Yorkshire Water Services
Land and Property
Western House
Western Way
Halifax Road
Bradford
BD6 2SZ

Your Ref: 2025/92737
Our Ref: A/02700

23rd December 2025

Rear of 23 to 43 Moor Lane, Gomersal, Cleckheaton - (KIRK) Discharge of details reserved by conditions 16, 17, 18, 19, 20 (drainage) on previous permission 2023/92079 for outline application for erection of residential development of 10 dwellings, demolition of existing extension at 27 Moor Lane, widening of existing access and realignment of boundary walls

Drawing Number: PV2511-APP-92-XX-DR-C-2500 Rev: P02

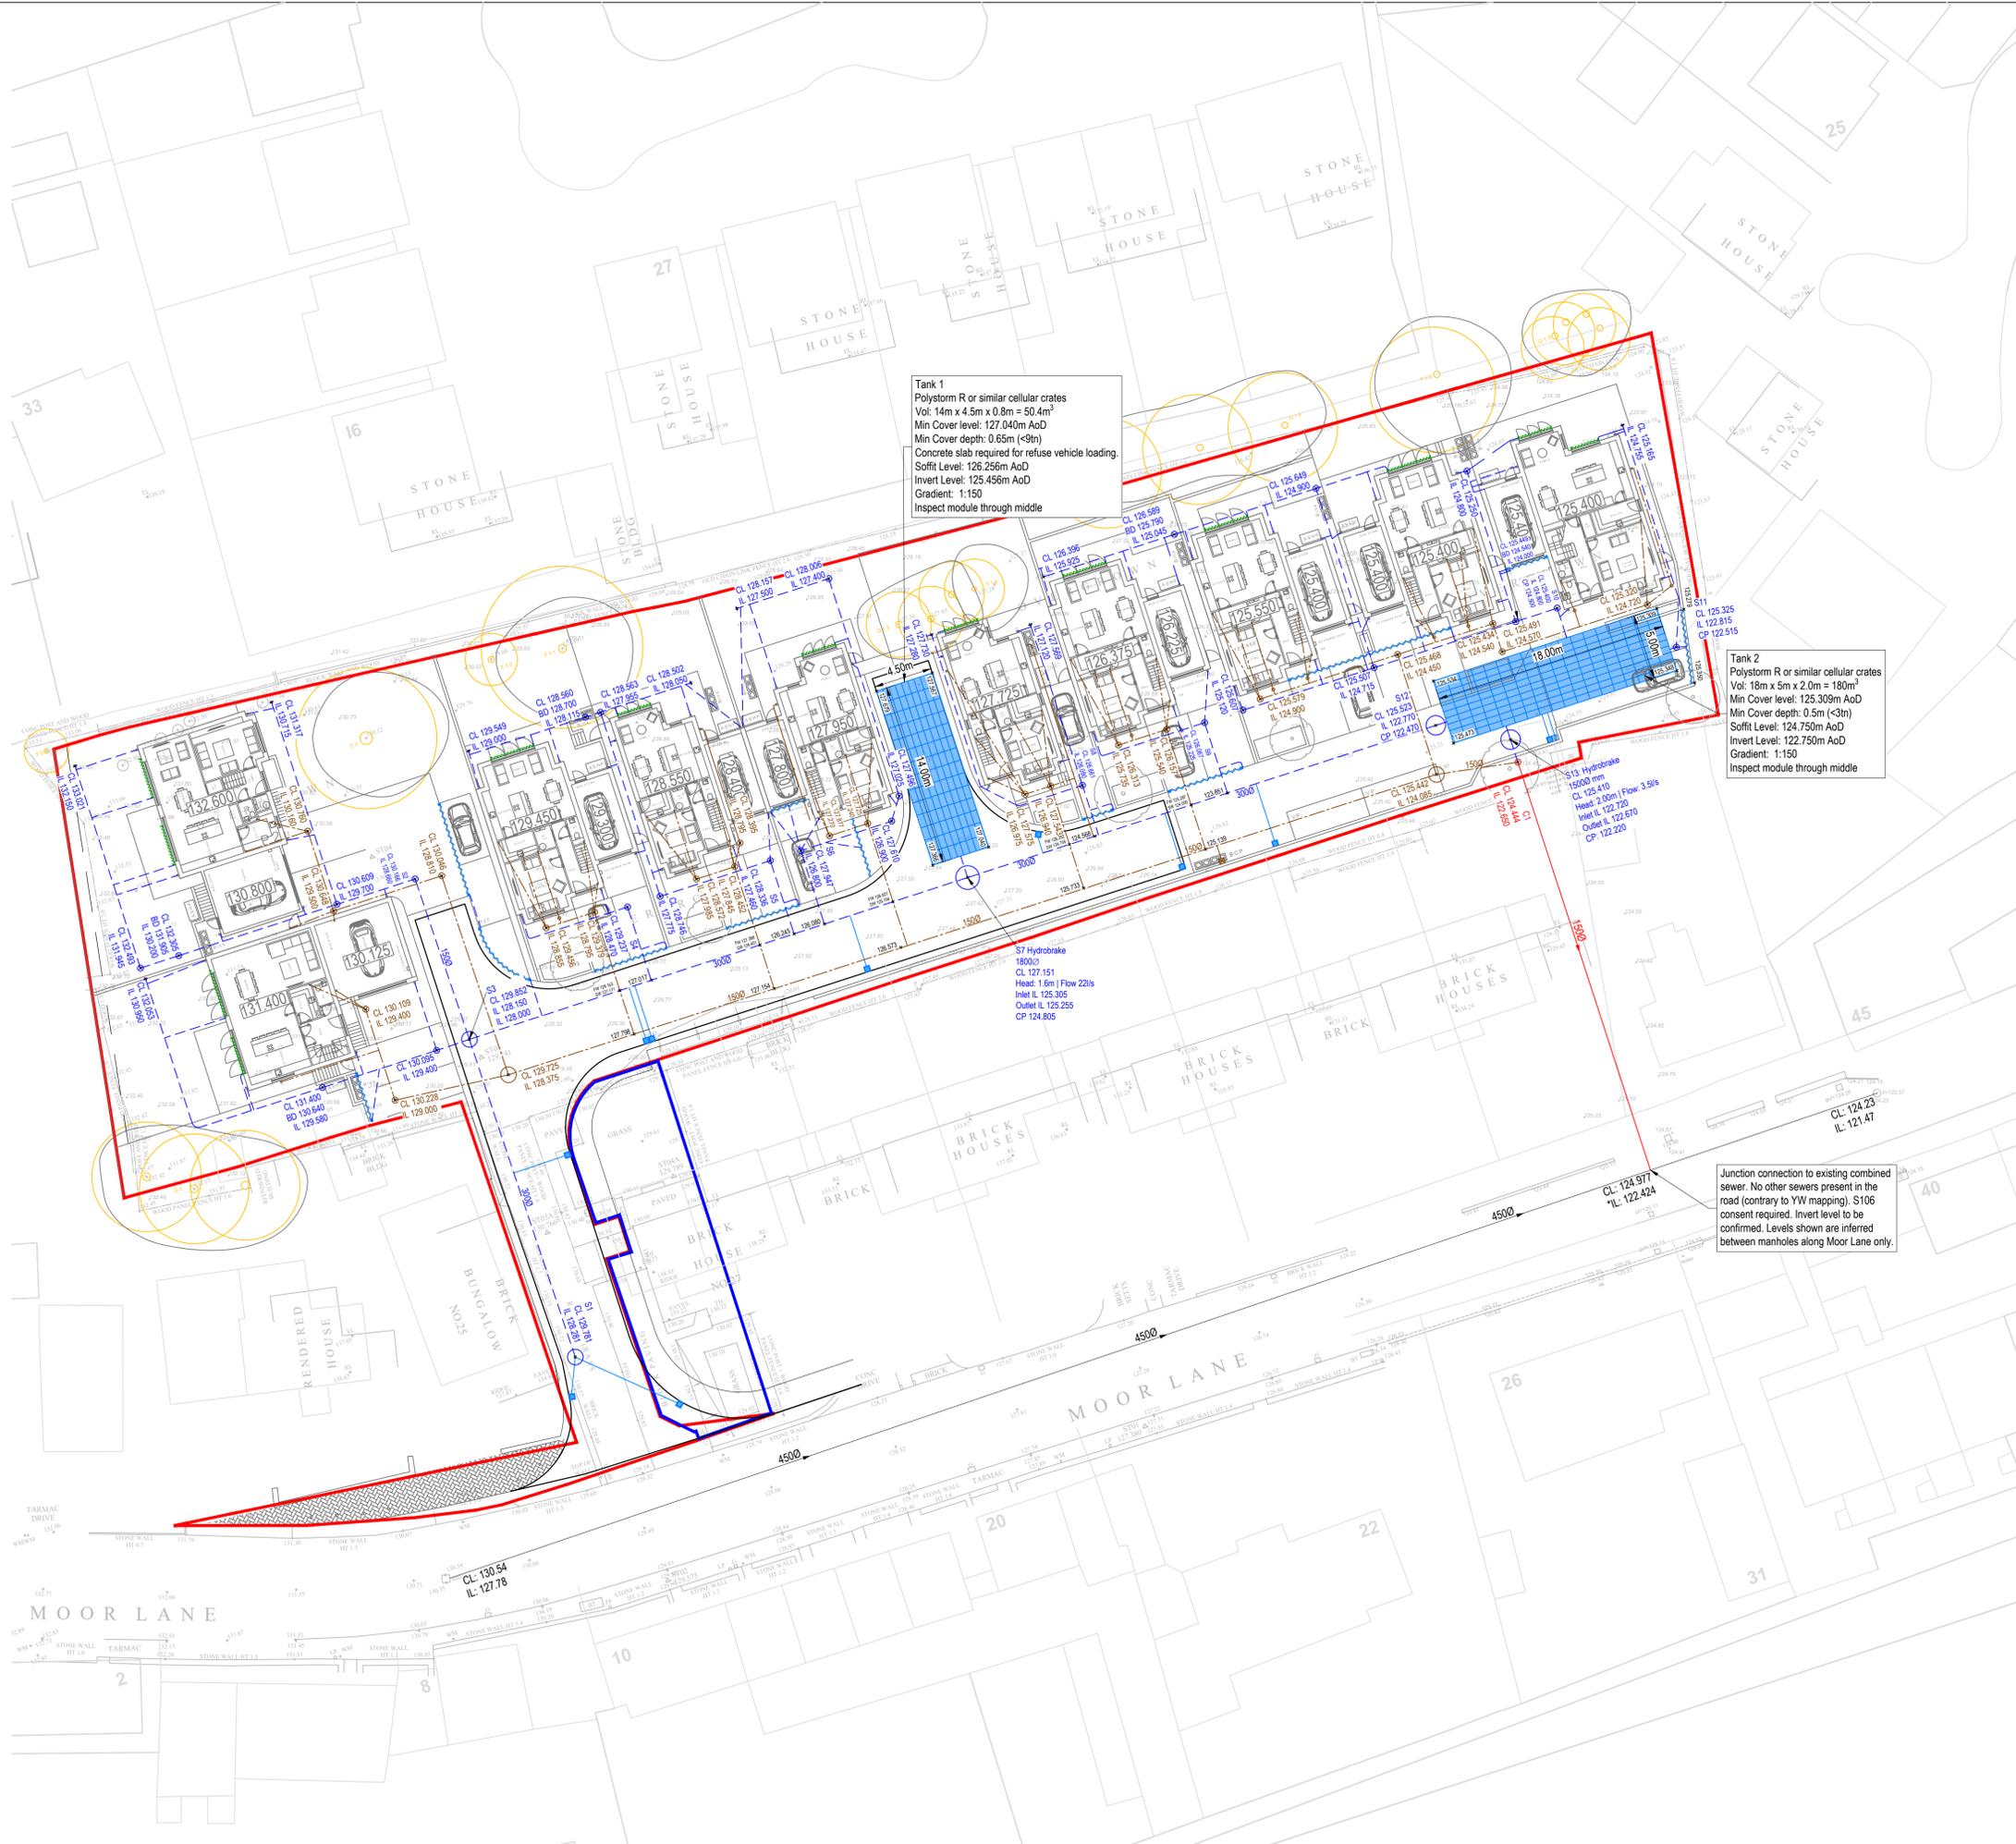
Yorkshire Water has no objection to discharge of conditions 16, 19 and 20.

Drawing PV2511-APP-92-XX-DR-C-2500 shows separate systems discharging foul water to the public combined sewer in Moor Lane and a surface water connection with flows limited to 3.5 litres/second discharging to the dedicated surface water sewer also in Moor Lane.
